PUBLIC SUBMISSIONS

Blue indicates additional shadow

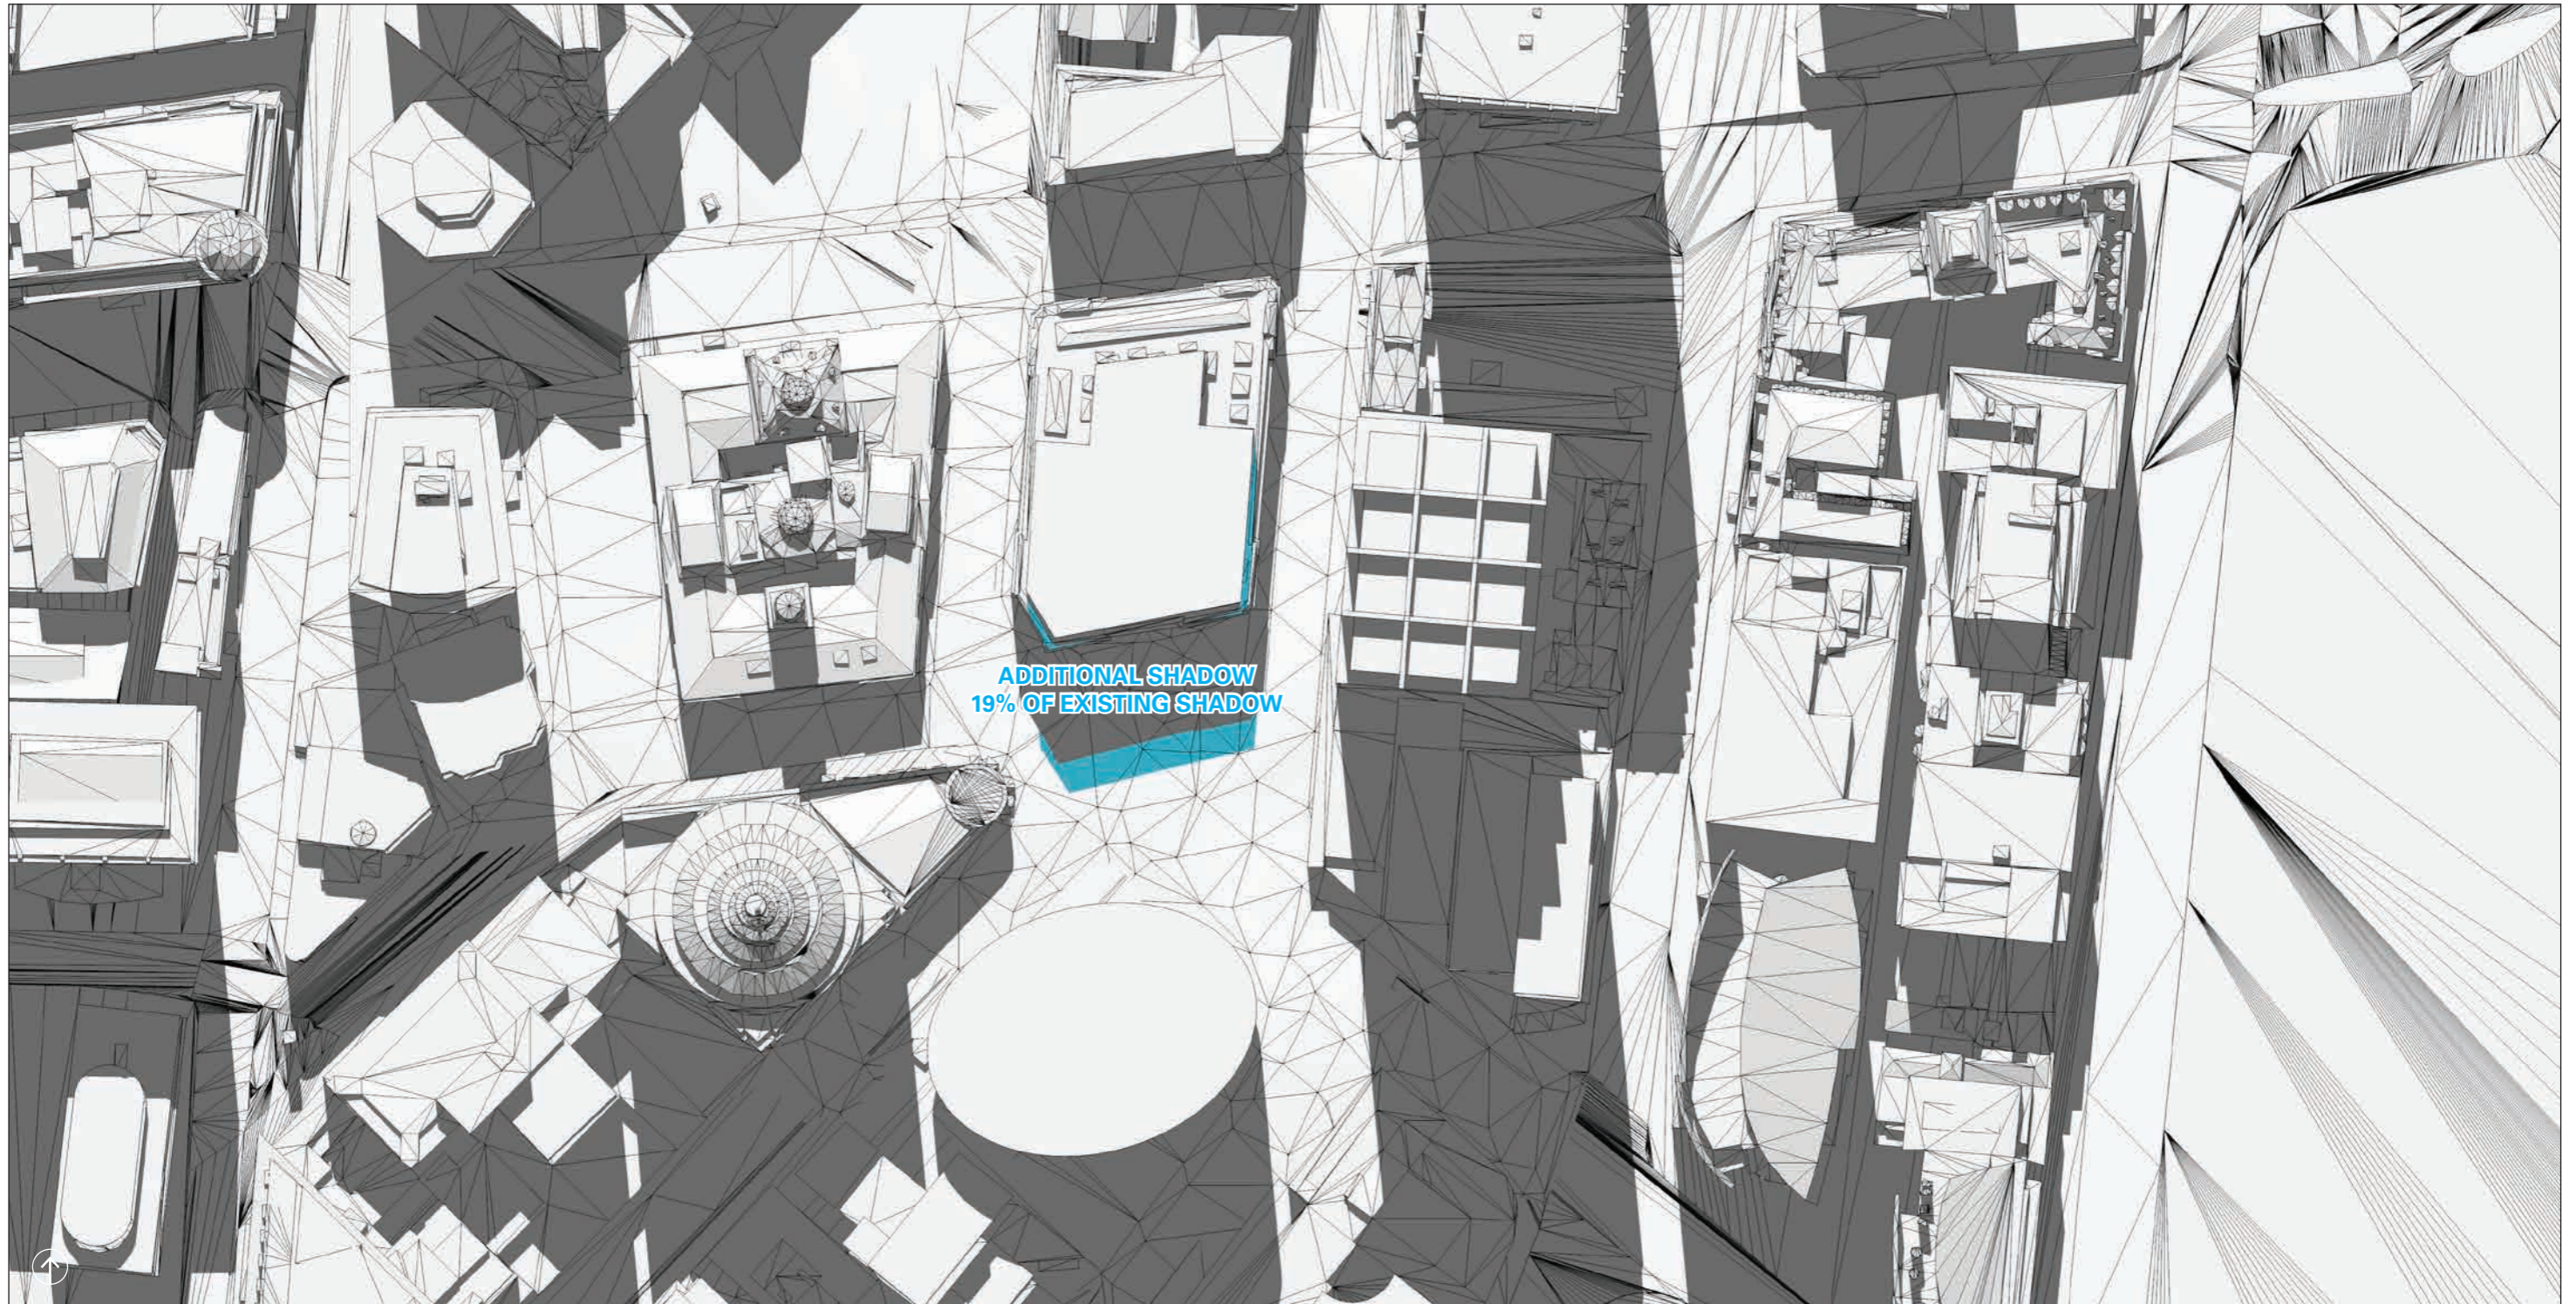
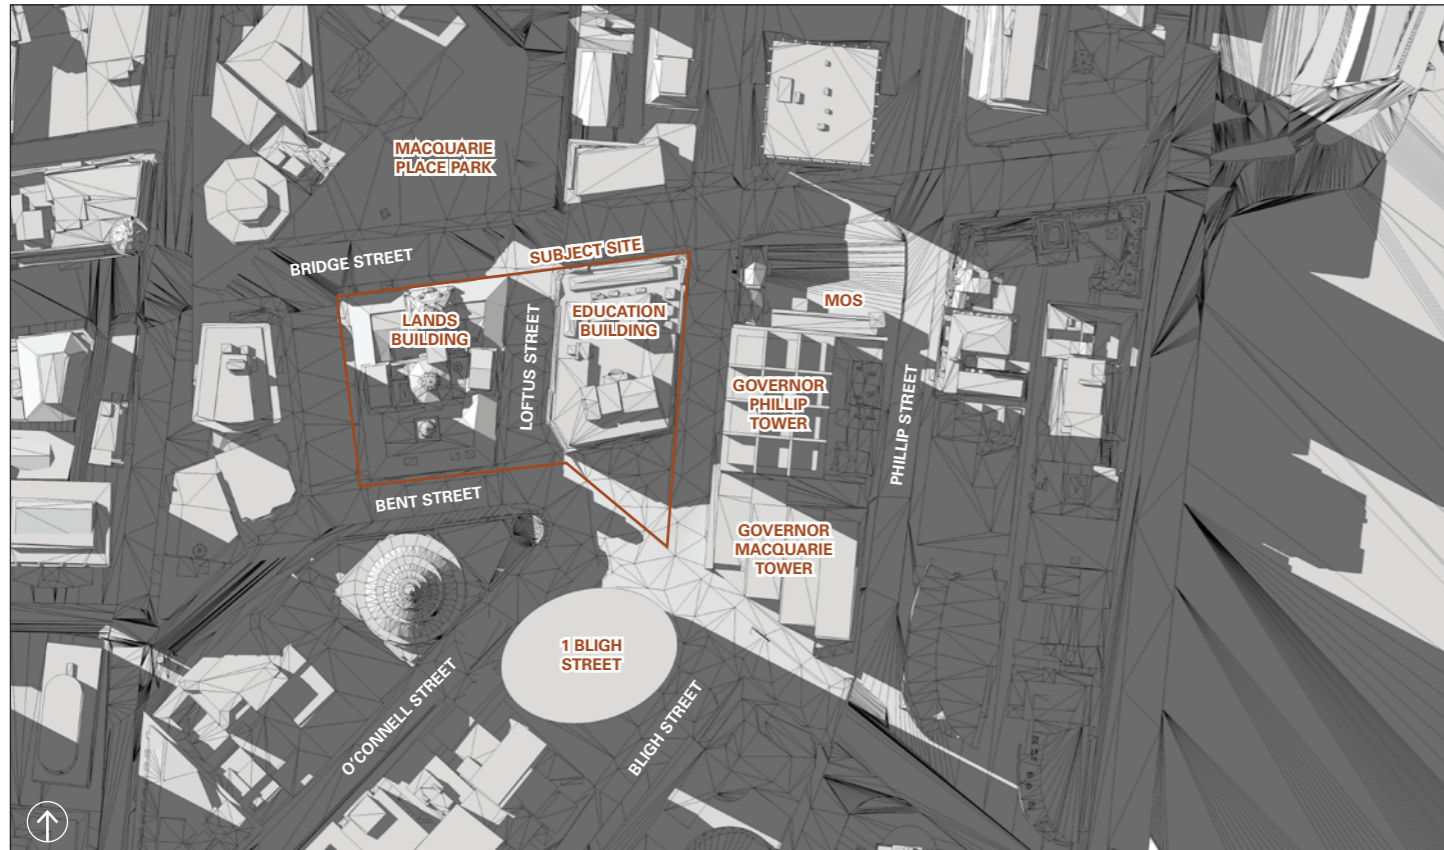
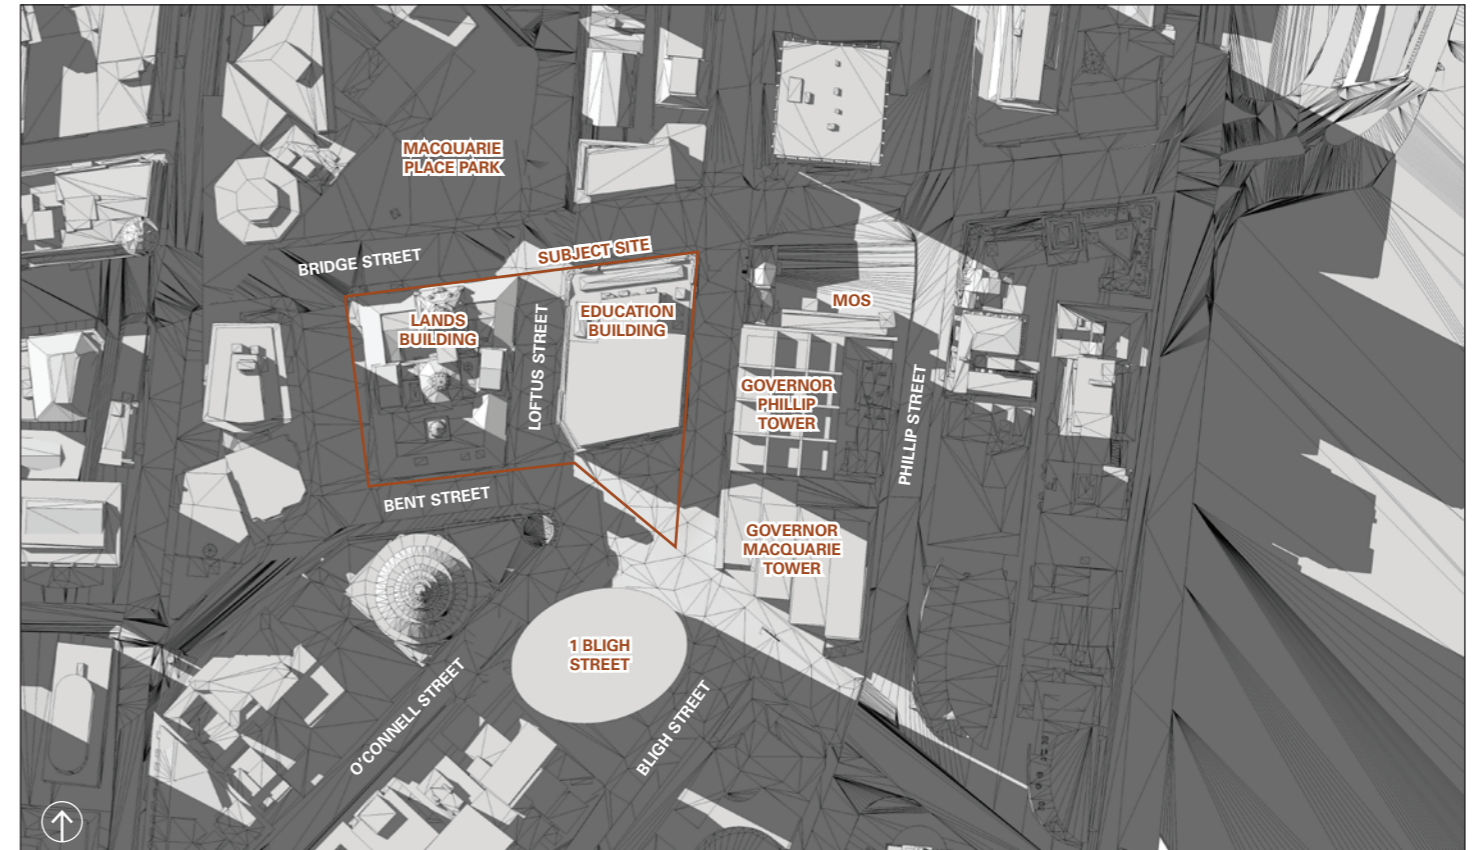
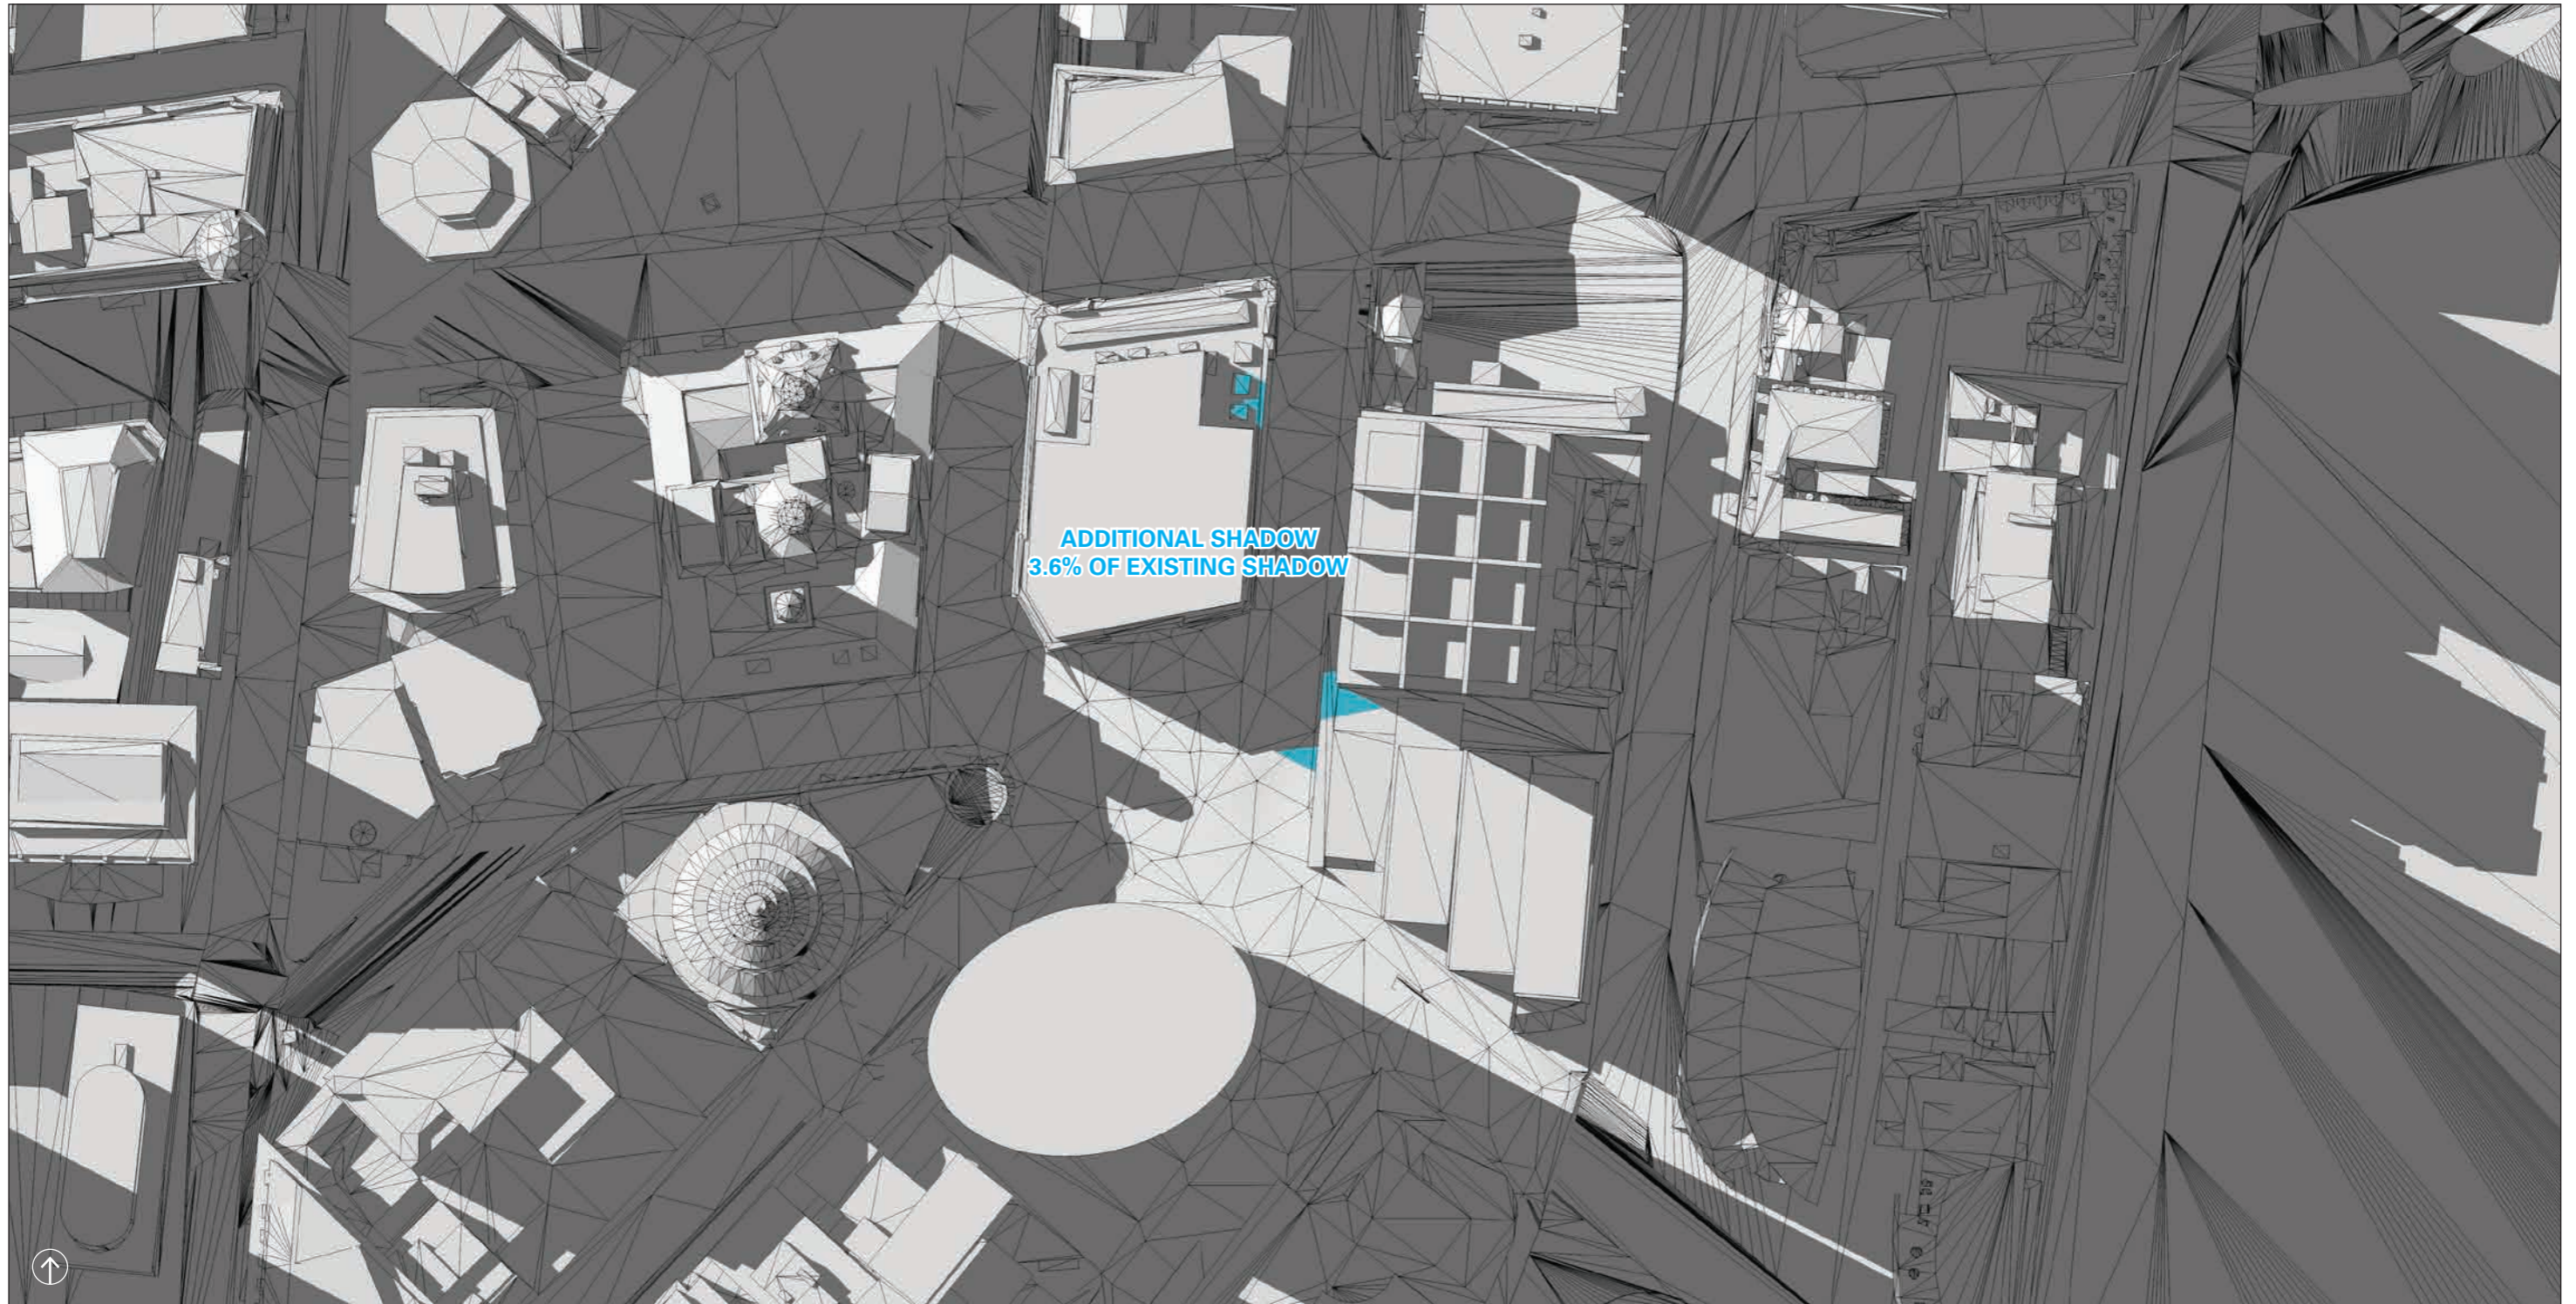
| <p>HEIGHT/OVERSHADOWING</p> <p>Increase in overshadowing</p> <p>Height increase is unacceptable when viewed from adjoining streets (should be setback)</p> <p>Rooftop additions should be setback</p> <p>The additional floors which create unacceptable shadow impacts on Farrer Place.</p> <p>The additional floors will create overshadowing on the Lands Building, which has not been addressed.</p> | <p>6</p> | <p>Clive Gunton</p> <p>Philip Drew</p> <p>WITHHELD</p> <p>WITHHELD</p> <p>John Freeman</p> <p>Peter Webber</p> | <p>See Section 2.1 of the Response to Submissions (RTS).</p> |
